We have reviewed the submitted EIS (click [here](#) to access it) SSD-72430958 - GDA - corner of Brookmanns Road and Canalla Road, Finley.

**Figure 2**  
**Development Site and**  
**Concept Layout**

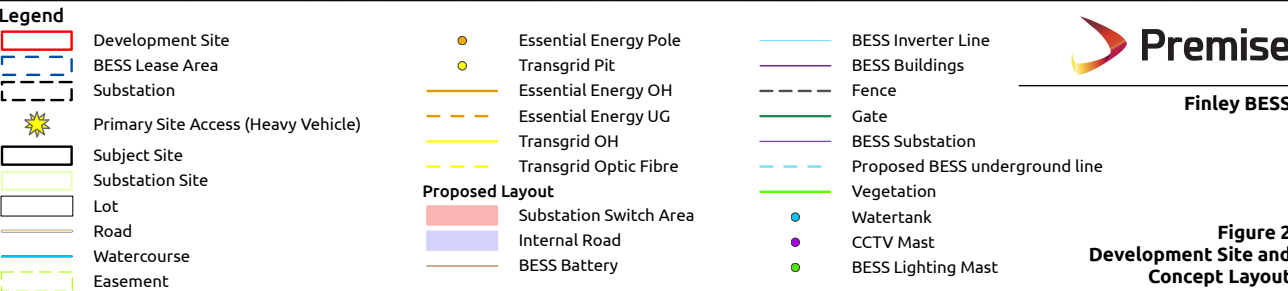
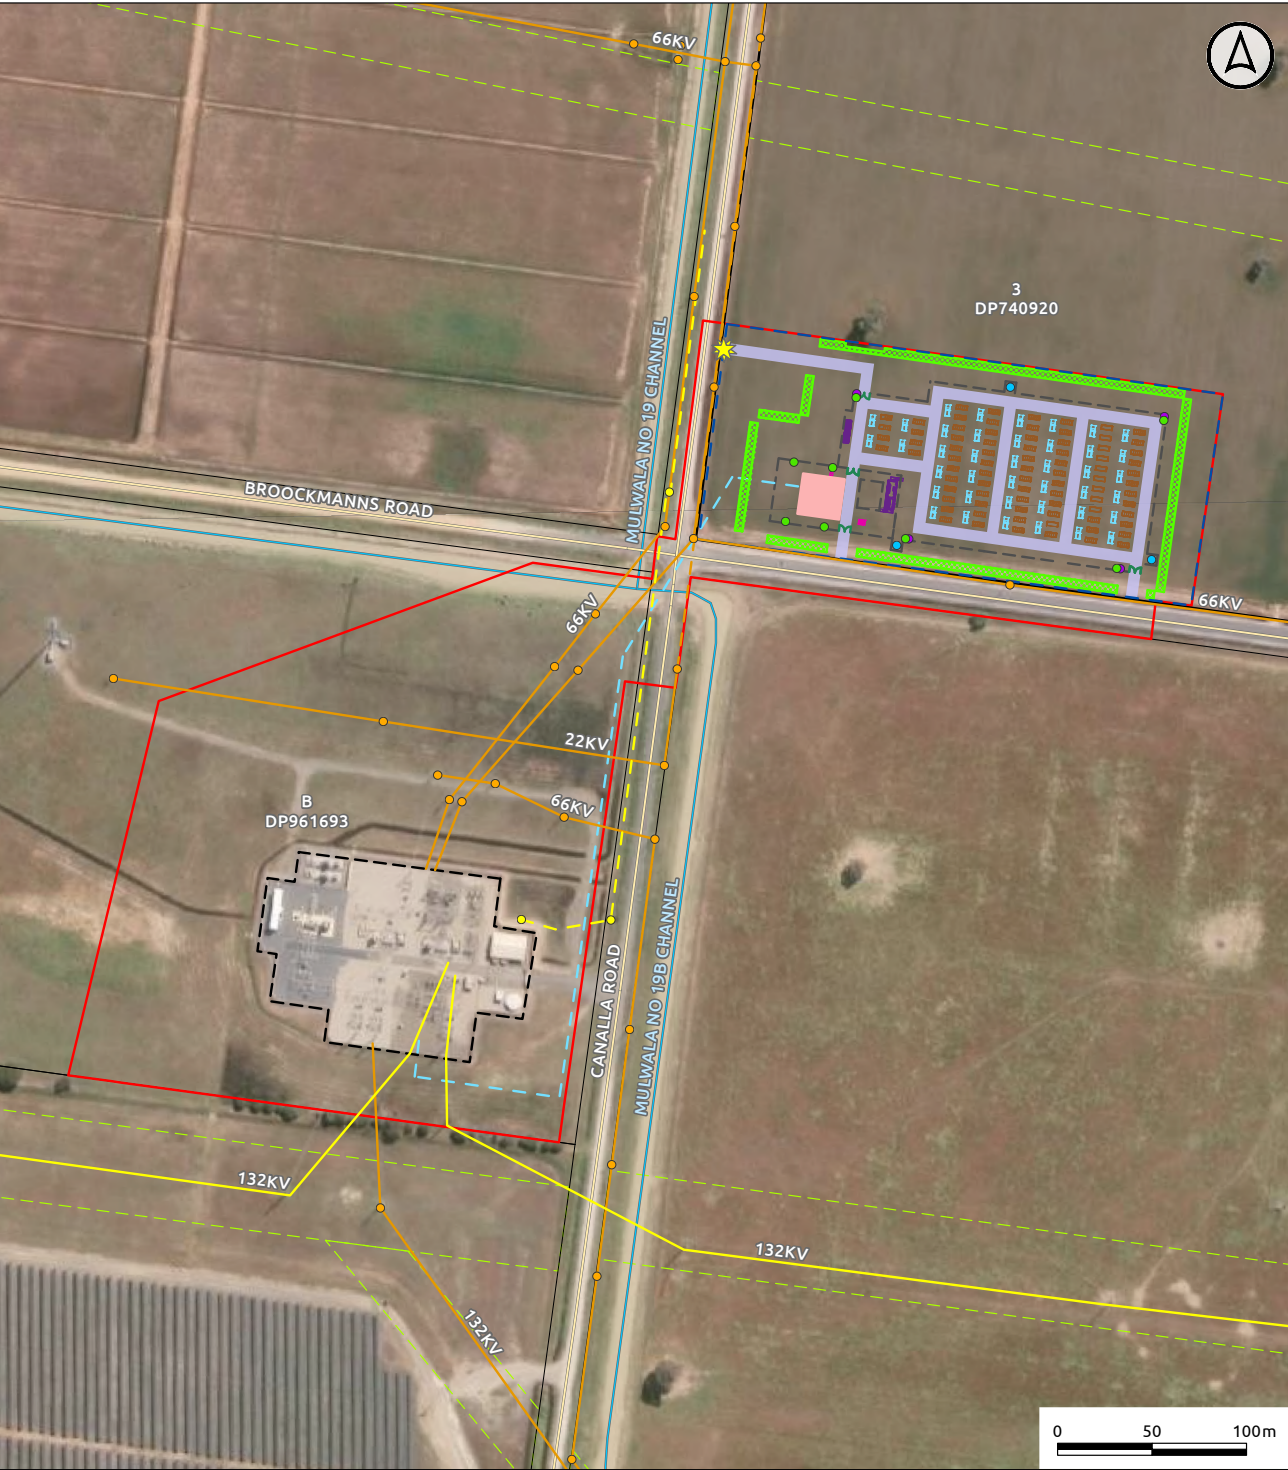
- Page 16 and 102 (workforce) encourages local employment, advertising locally and sourcing material locally where possible. This is fully supported.
- No specific screening details have been provided (such as vegetation species, height at maturity, density, etc). Can these details please be included.
